**KIRKLEES METROPOLITAN COUNCIL
INVESTMENT & REGENERATION SERVICE**

**DELEGATED DECISION FOR DISCHARGE OF CONDITION A.4 -
NOTIFICATION OF A PROPOSED ENLARGEMENT TO DWELLINGHOUSE**

Reference no.	2025/HH/91303/E
Site Address	Clough Farm Meadow, 34, Tolson Street, Ossett, WF5 9QH
Description	The proposal is for erection of single storey rear extension. The proposed extension projects 7m beyond the rear wall of the original dwellinghouse. The maximum height of the extension is 3m, the height of the eaves of the extension is 3m
Recommending Officer	Joanna Rednall

Drawing Title **SITE PLANS**

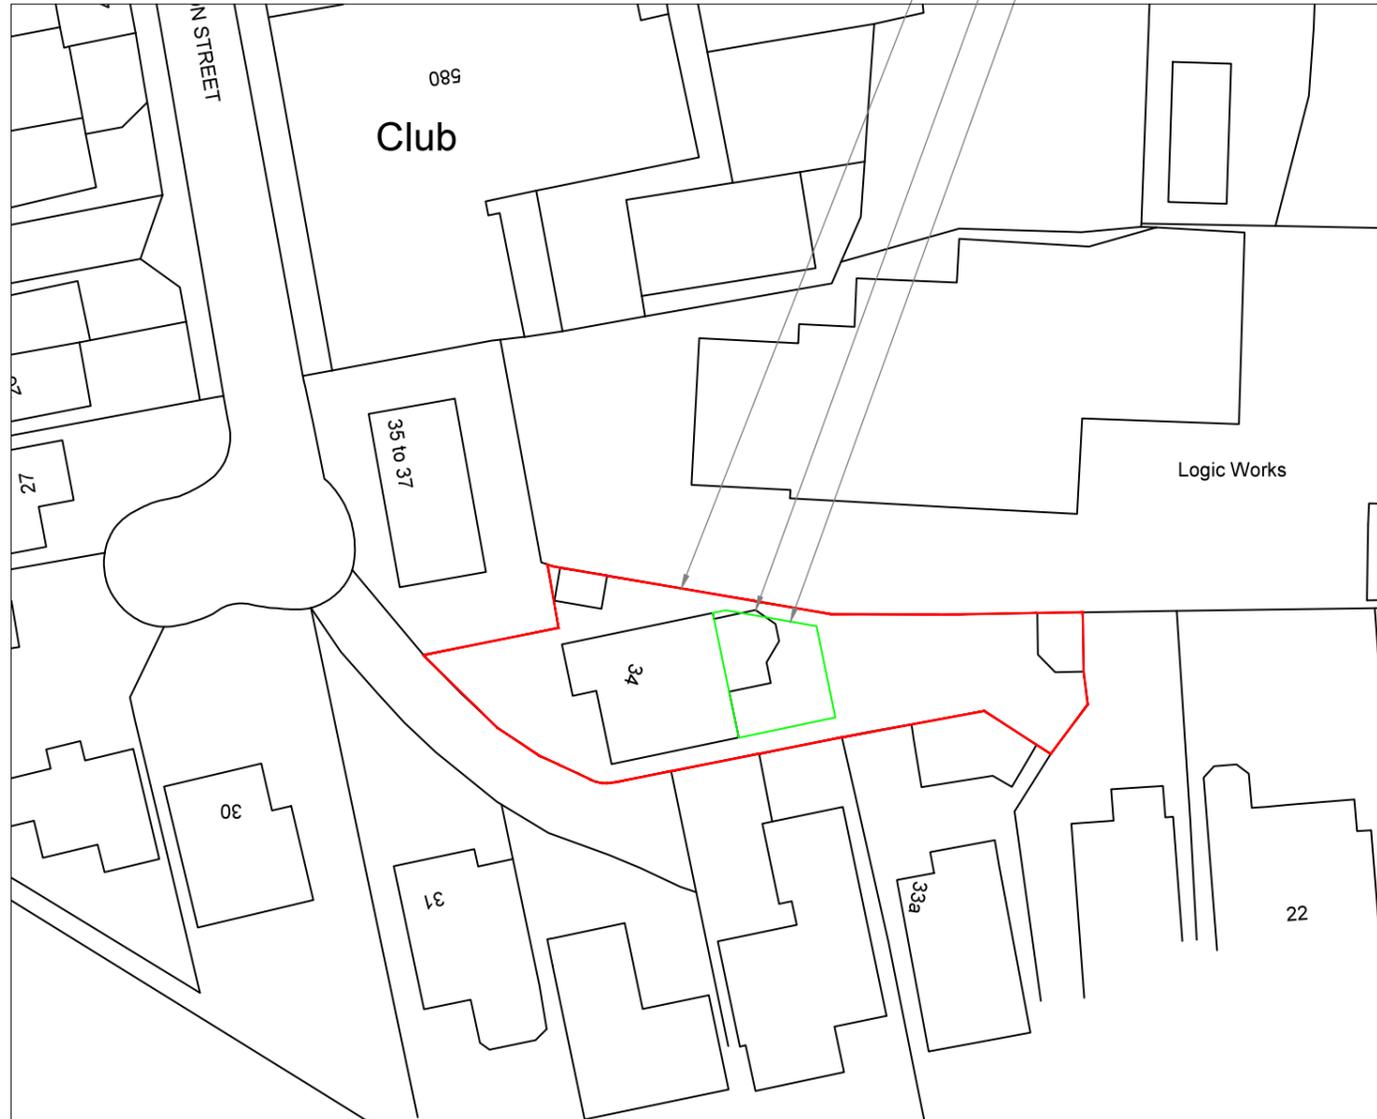
Given the separation distance and the single-storey scale of the proposal, the extension is not considered to result in an overbearing impact on No.33A. The block plan demonstrates that the proposed development would align with the existing two-storey garage projection of No.33, further reducing its visual prominence. The relationship between the properties and the limited scale of the extension would prevent it from appearing unduly dominant or oppressive when viewed from this neighbouring dwelling.

The proposed extension would be positioned approximately 1 metre from the shared boundary, which is currently defined by a close-boarded fence providing an established level of screening. While the existing conservatory is built along the boundary, the submitted plans indicate that the extension would increase the footprint of built form in close proximity to this boundary. However, taking into account the existing boundary treatment and the separation distance of approximately 9 metres between the proposed development and the neighbouring building, it is considered that the extension would not result in any undue harm to the amenity of occupiers of this building.
